**Kittitas County Public Works
411 N Ruby ST, Suite 1
Ellensburg WA 98926**

RE: Brown & Jackson SE20-00003

land parcel is 295134 Sewage Dump Ponds

**BROWN & JACKSON**  
 Land Application Site  
 Preliminary  
 Site Map  
 Kittitas County  
 Washington

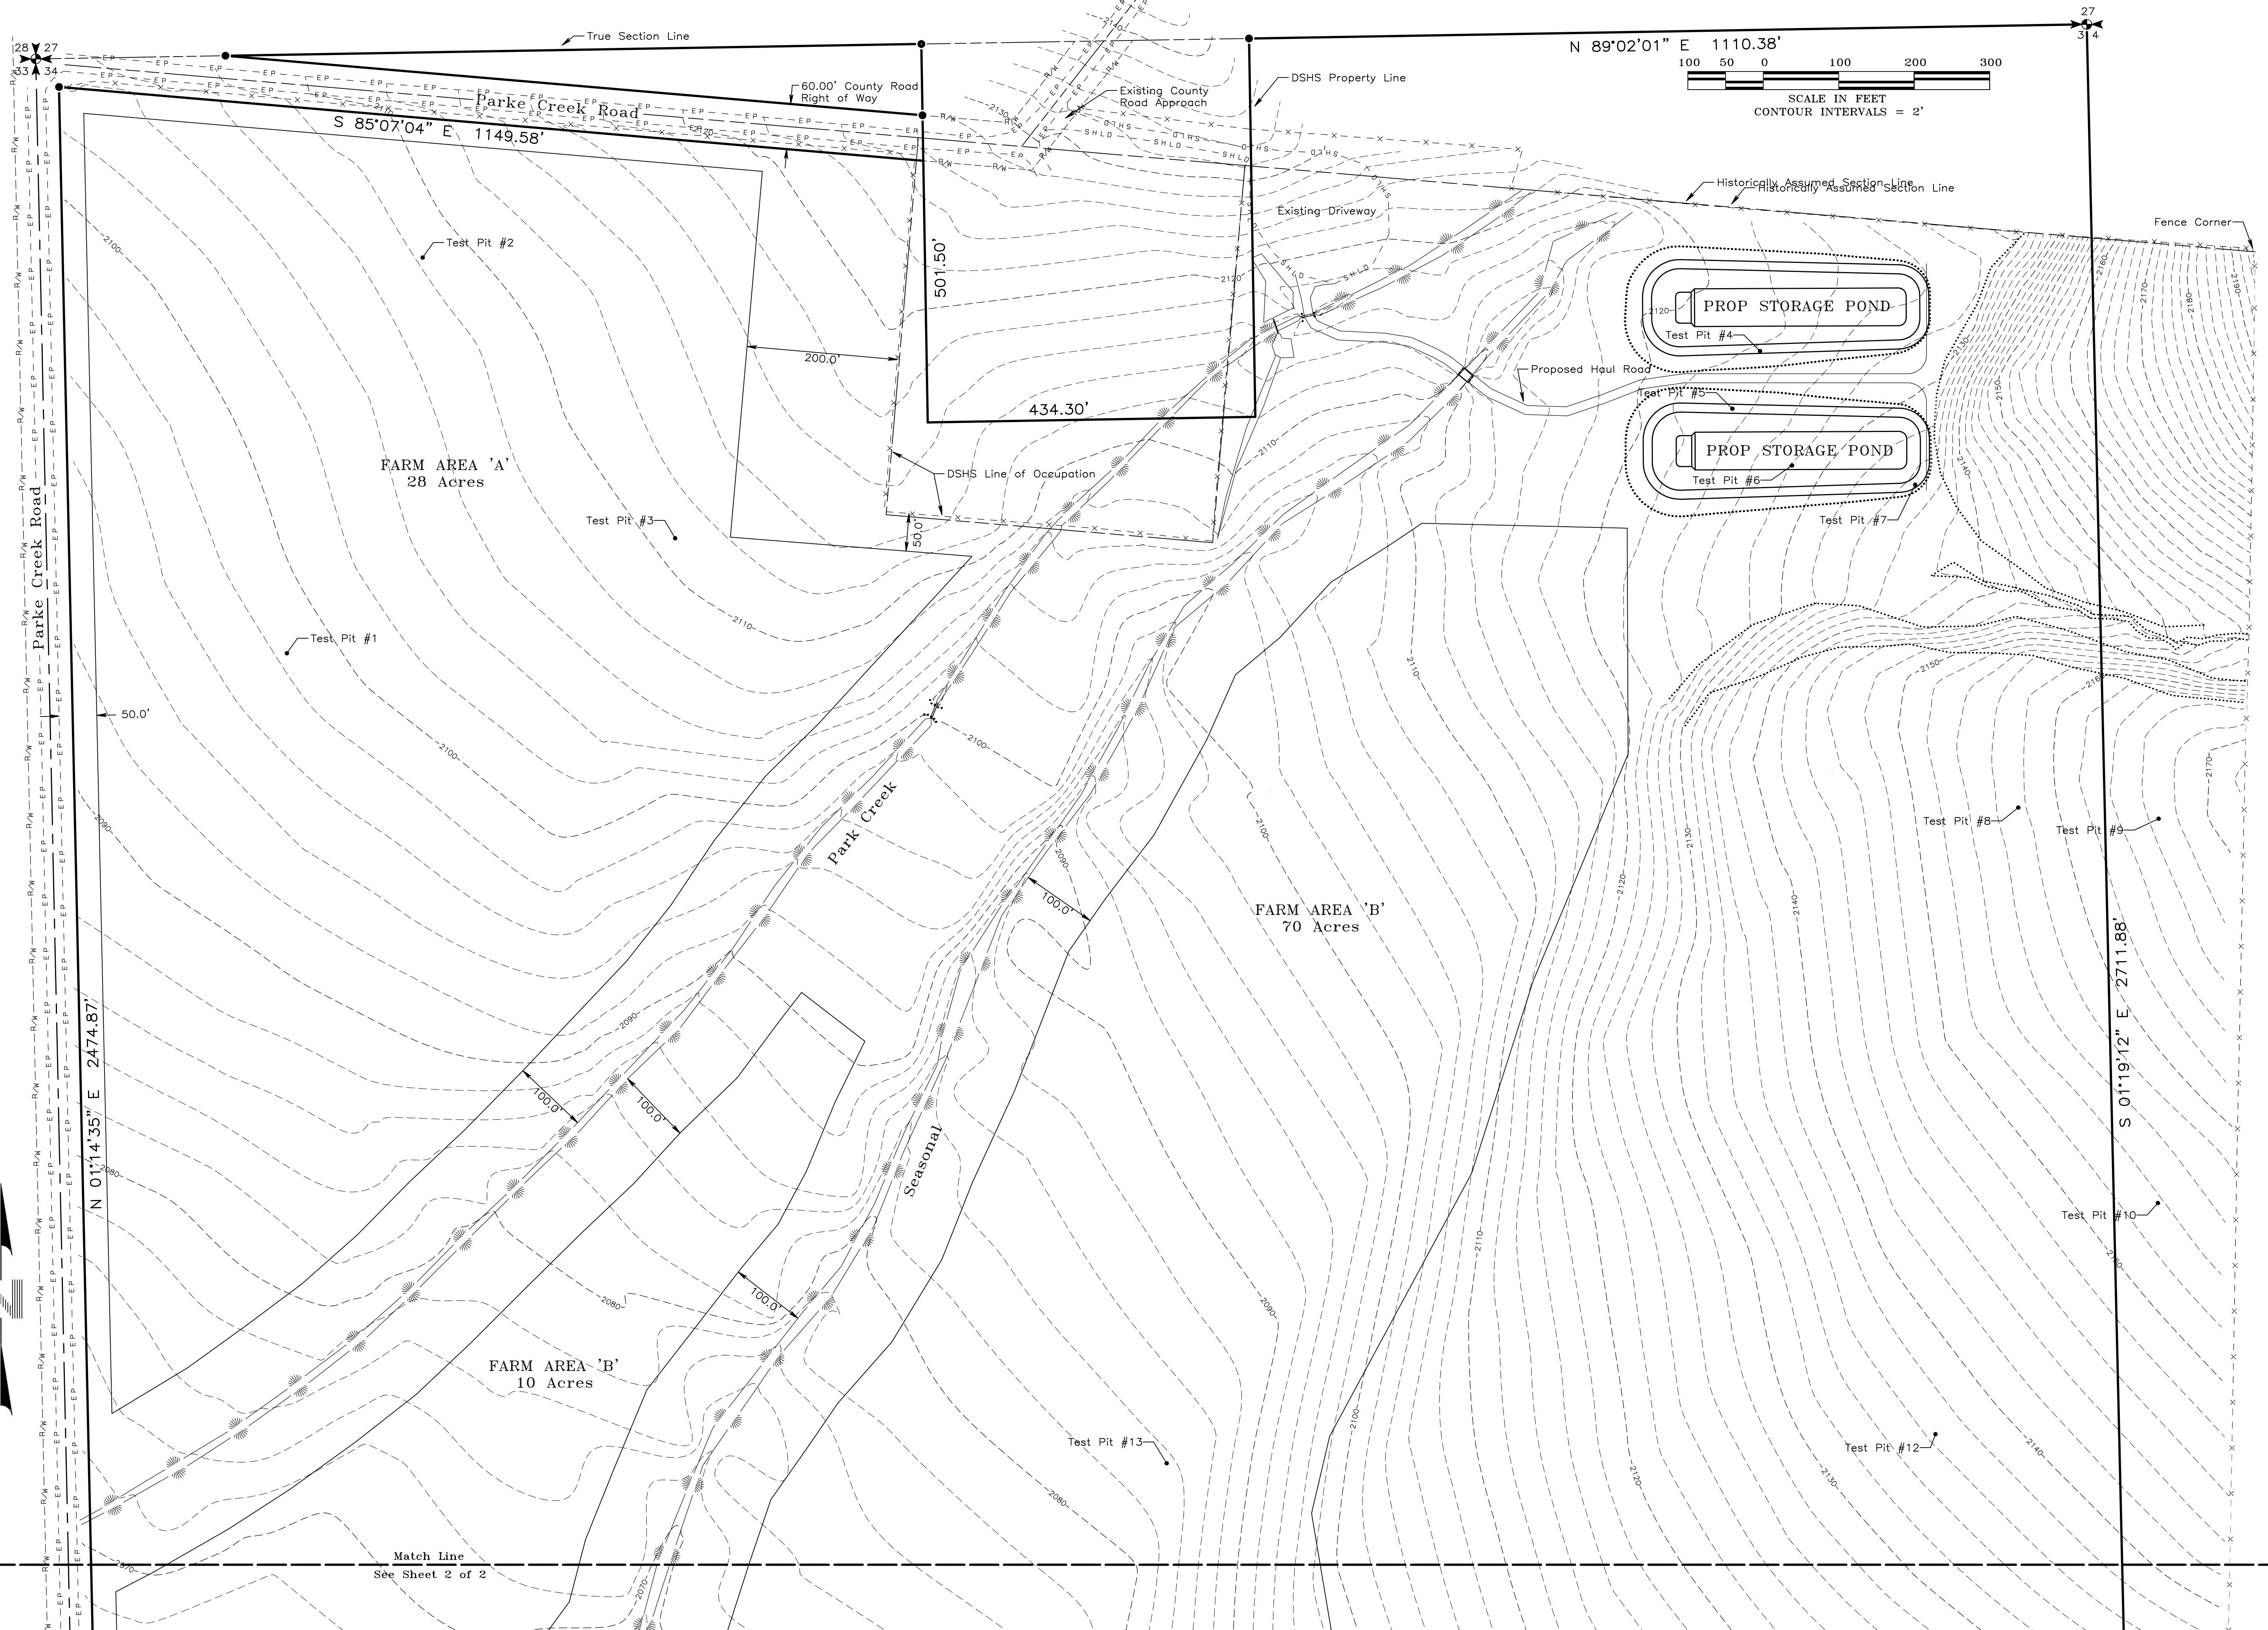
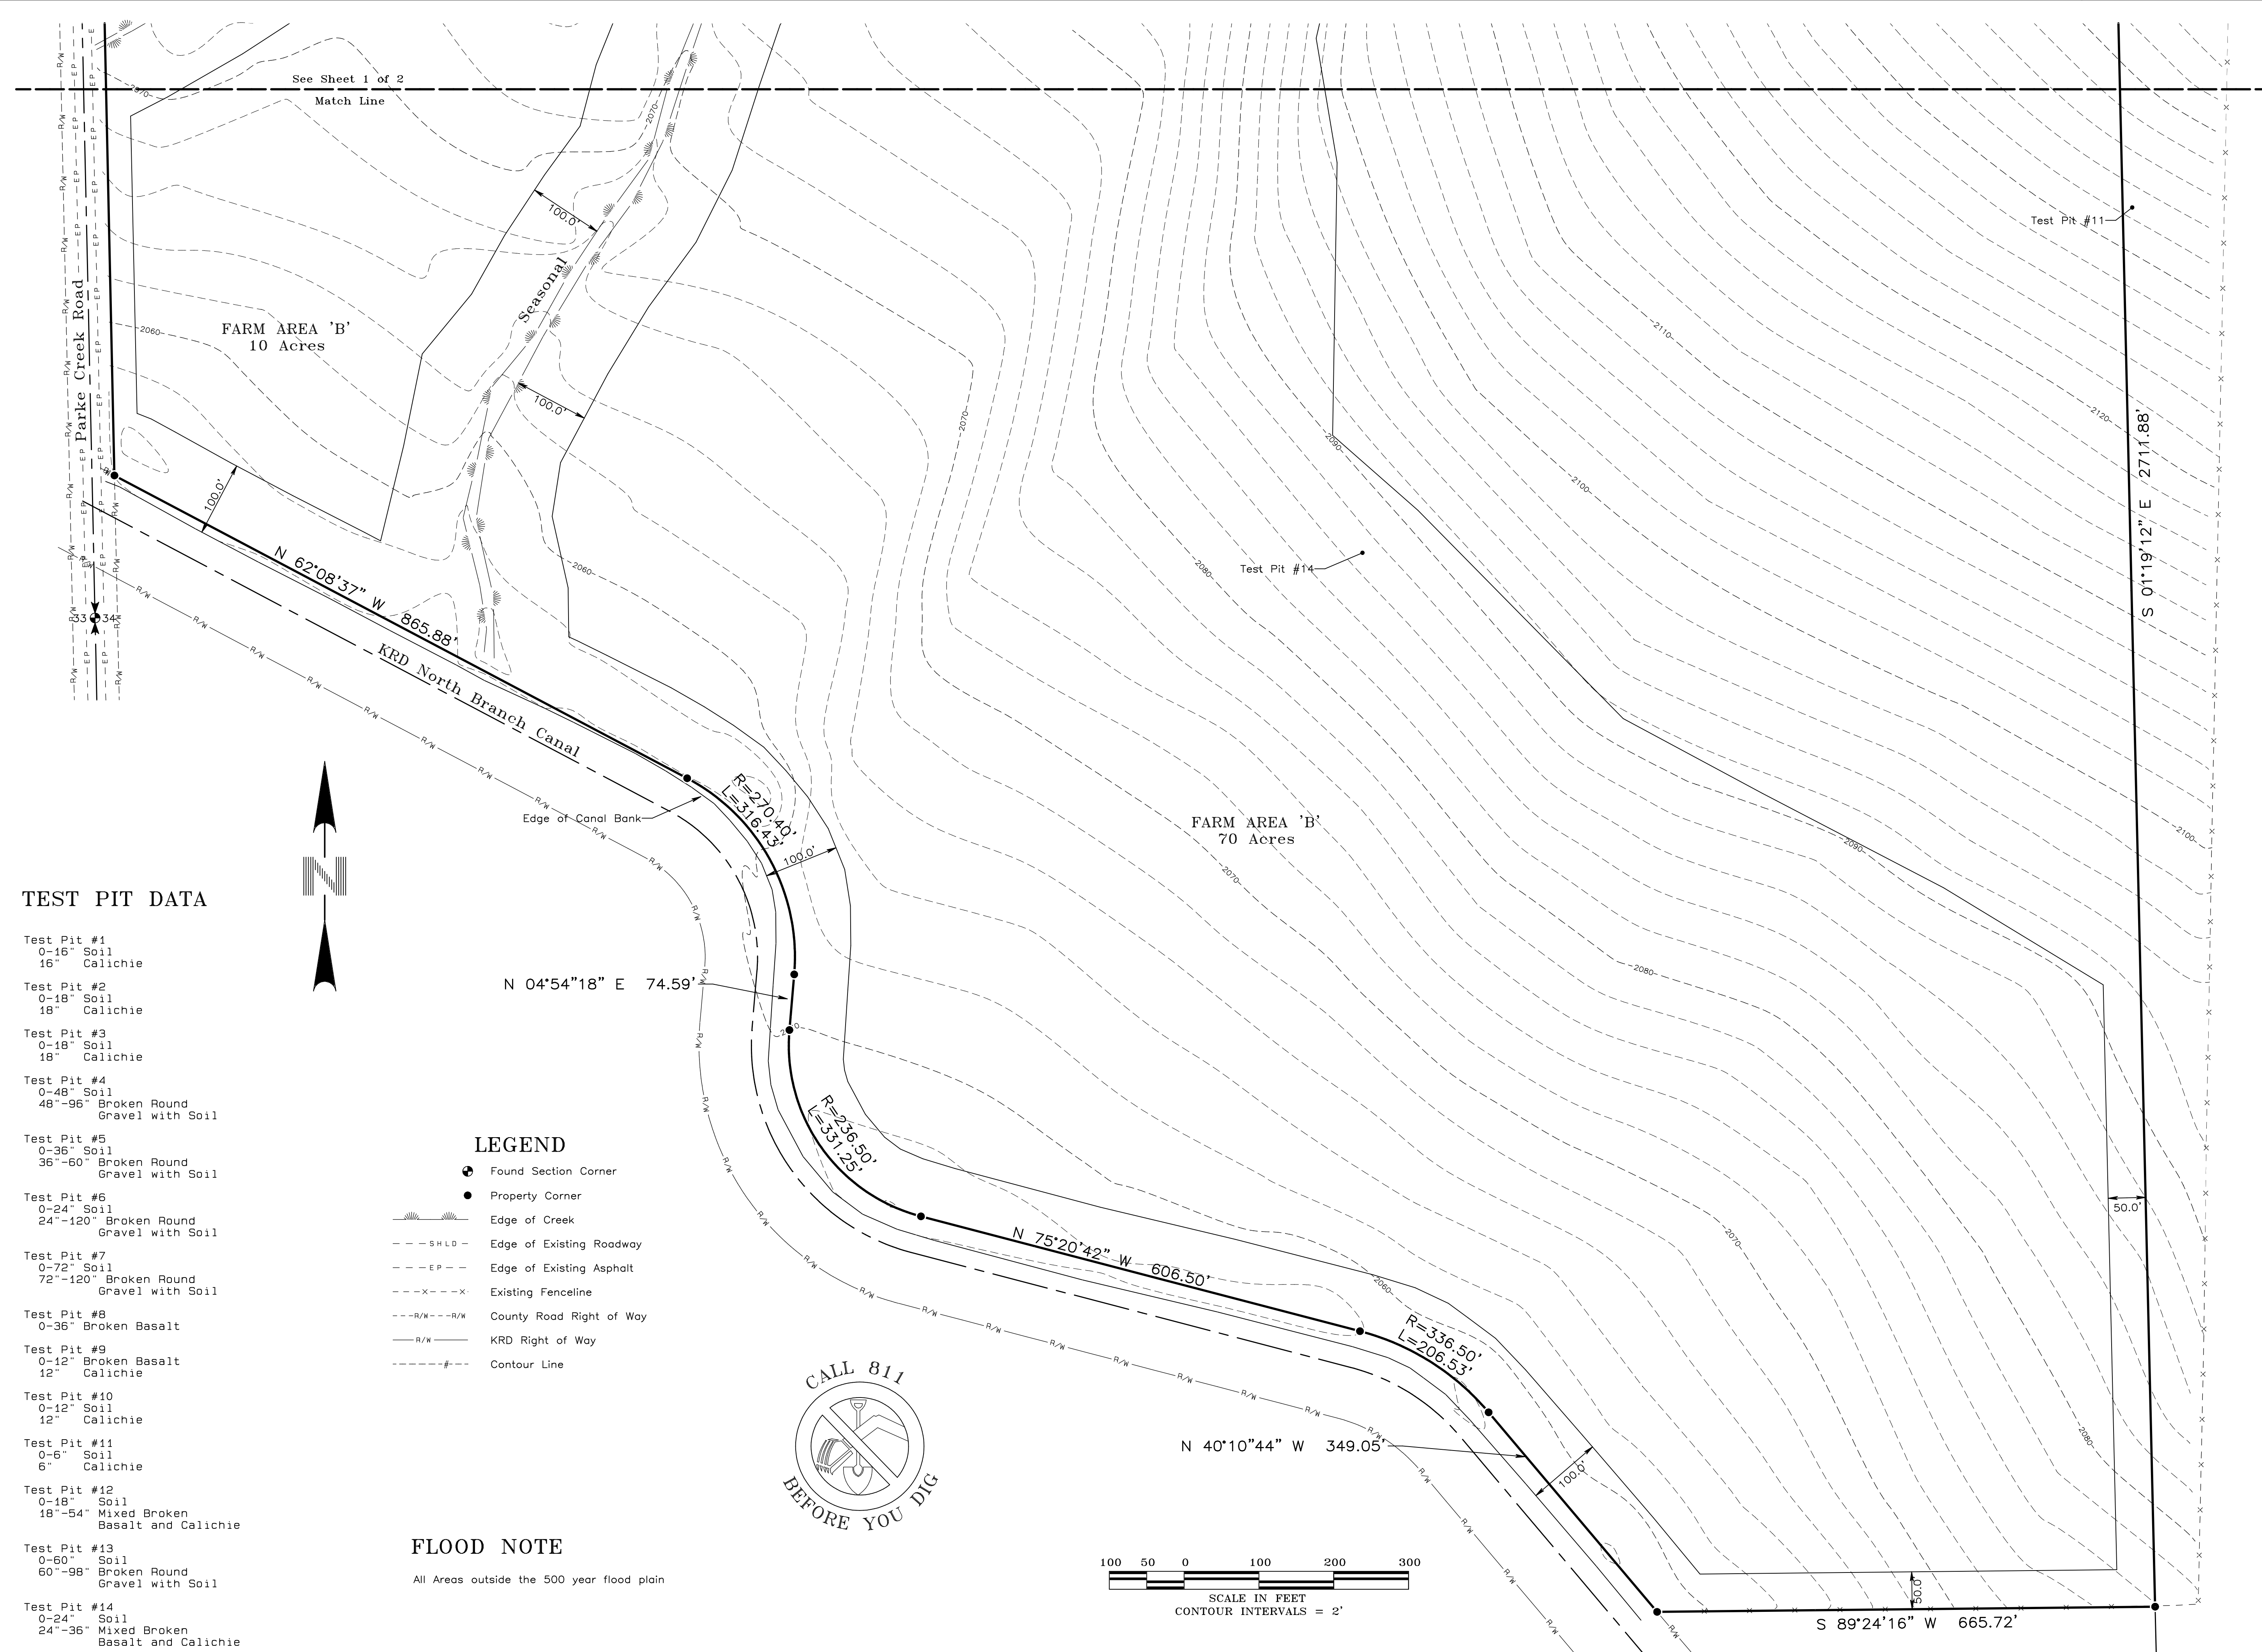
The Engineers' Report identifies disking/ tillable crop areas that are full of rocks too large for disking without mention in the report. That to me, puts that report in serious question. The application or report states a distance from the pond to Parke Creek being 300 feet. However, using the drawing scale on the report proves that it is only 100+/- ft from the creek closest to nearest pond. These creeks become one when the floods come with the spring thaw. Has anyone from the County inspected the site vs Engineers' report for accuracy? The County has engineers that can and should verify these proposals.? Applicants should be required to provide an AutoCad copy of submitted drawings. If so, that drawing should be made accessible to the public. There are free online applications that would allow the public's review in a larger scale. They do not need the actual program to read the file. The drawing can be locked from editing ability, but still be scalable.

The pit containment perimeter area is approximately 50 ft uphill on the eastside of Parke Creek. Not 300 ft as specified elsewhere. The Engineers' test pit data report states "24" of topsoil and then broken round gravel to 120 ft in this area with no liner indicated. It seems to me that this will allow seepage onto Parke Creek.
